**EPA Advice on Submissions Report - SSD-67497708
Aussie Skips Recycling - Bellfrog St Site upgrades**

- Reviewed the Submissions Report provided, titled *Aussie Skips Recycling Bellfrog St Site Upgrades (SSD-67497708) Submissions Report - ref. E250438 RP#3, version 1*, as prepared by EMM Consulting Pty Ltd and dated 27 February 2026 (**the Submissions Report**); and
- Considered the EPA's previous submissions to DPHI regarding the Proposal and SSD-67497708, including:
 - The Secretary's Environmental Assessment Requirements (**SEARs**) requirements dated 29 February 2024 (notice no. 1637398, DOC24/110492-4) and 13 May 2024 (DOC24/356005); and
 - The Environmental Impact Statement (**EIS**) (DOC25/973133-4) dated 16 December 2025.

EPA'S ADVICE ON SUBMISSIONS REPORT (SSD-67497708)

The schematic model layout is shown below:

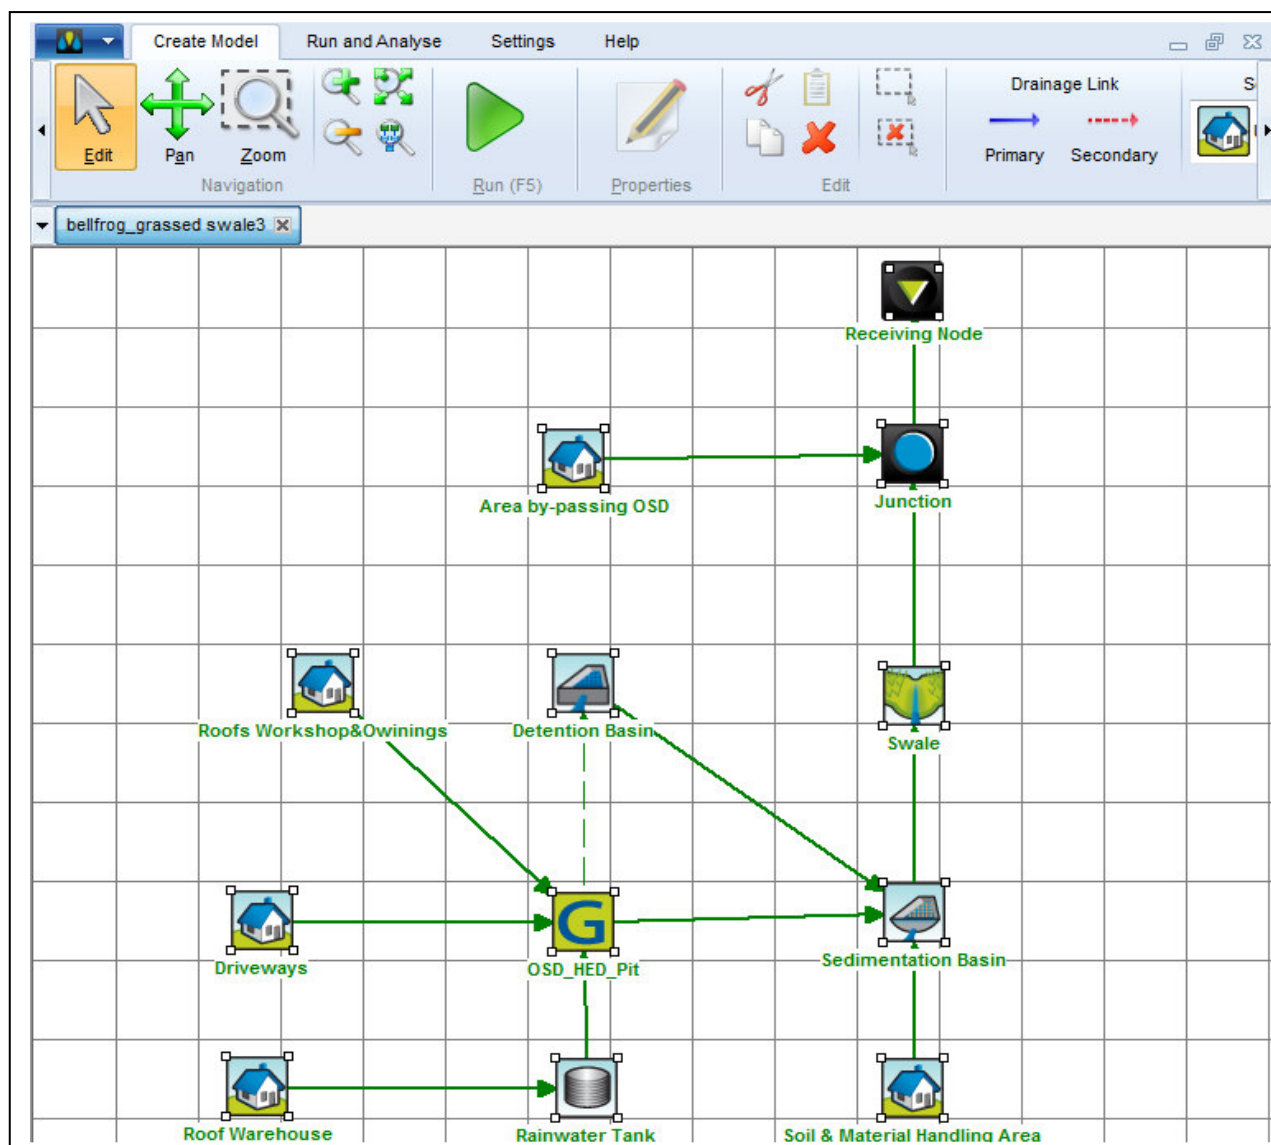
- For example:
 - The Applicant did not provide updated MUSIC modelling, despite this being specifically addressed by the EPA as a deficiency within the EIS and required assessment.

- The Applicant appears to justify its omission of the required modelling on the basis that the cost of procuring the modelling is "*not justified*", as upgrades to water management infrastructure by the Proposal will "*achieve the same or better reductions in pollutant loads*".

Figure 5.1 Site enclosure site layout

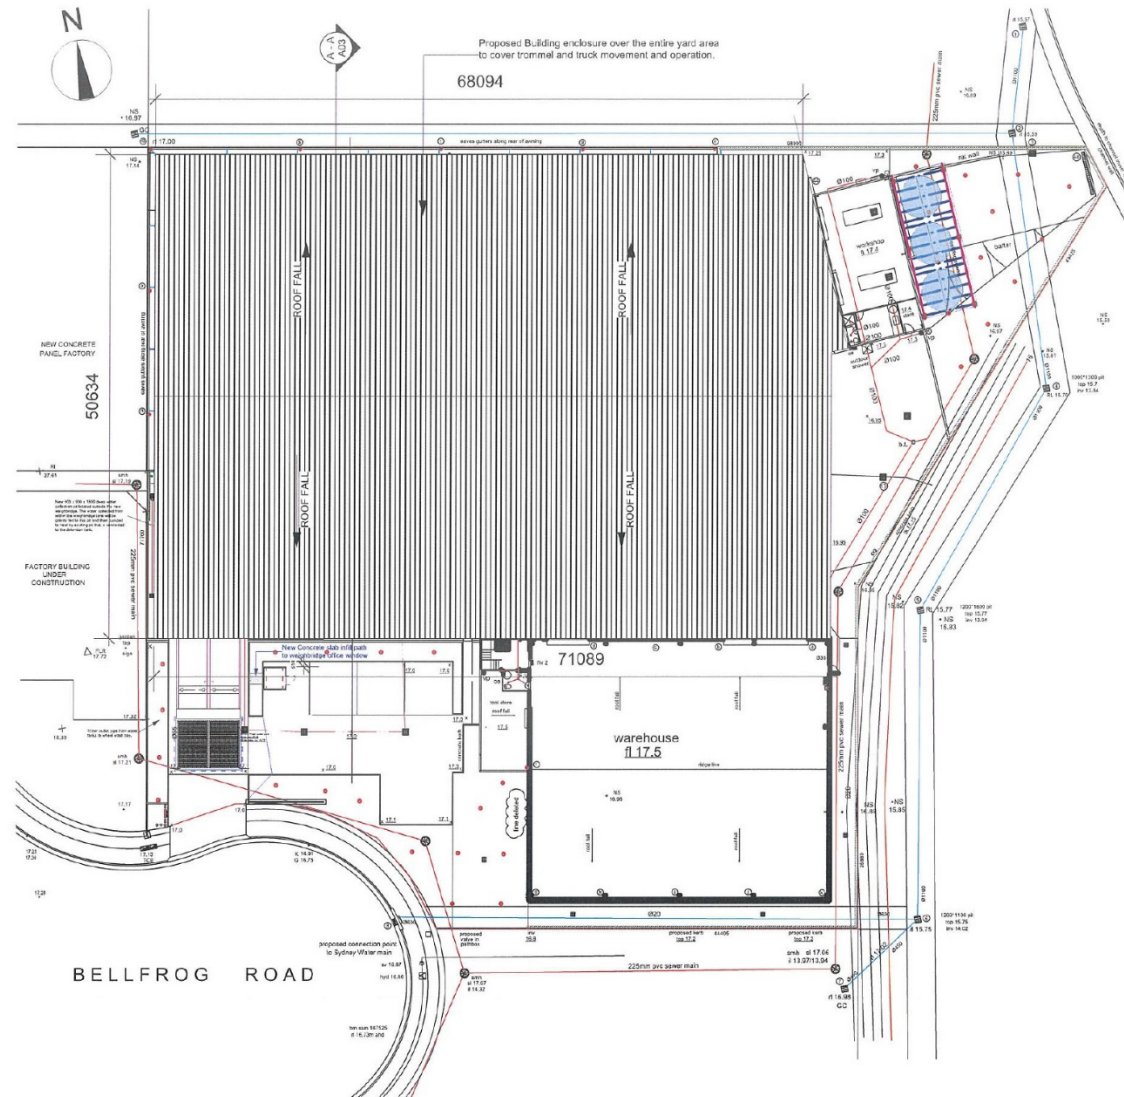
- The Submissions Report references the updated AQIA when reiterating preference for the Proposal's "MRF enclosure" scenario (**Scenario 1**) as compared to the "Full site enclosure" scenario (**Scenario 2**). The response provided within the Submission Report purports that both Scenario 1 and 2 present "*fully enclosed scenarios*", despite Scenario 1 including an "*open concrete yard between the weighbridge and receipt building*".

- The Submission Report provides that both scenarios 1 and 2 present "*equivalent*" and "*comparable*" environmental and compliance outcomes, as the updated AQIA modelling has demonstrated similar PM₁₀ exceedances for each scenario.

- The EPA is of the opinion that comparison should not only be made to the count of predicted exceedances of environmental assessment criteria, and that in doing so, the Applicant has overlooked lower incremental concentrations and the overall risk reduction demonstrated by AQIA modelling presented for scenario 2.
- The Submissions Report has not provided sufficient justification to support the continued preference for a scenario that appears to present a higher level of environmental risk than the alternative proposed, nor has it adequately demonstrated that compliance with the Applicant's obligations under the Act would be achieved.
- As such, the EPA restates its expectation that the Premises be fully enclosed under any planning approval issued for the Proposal.
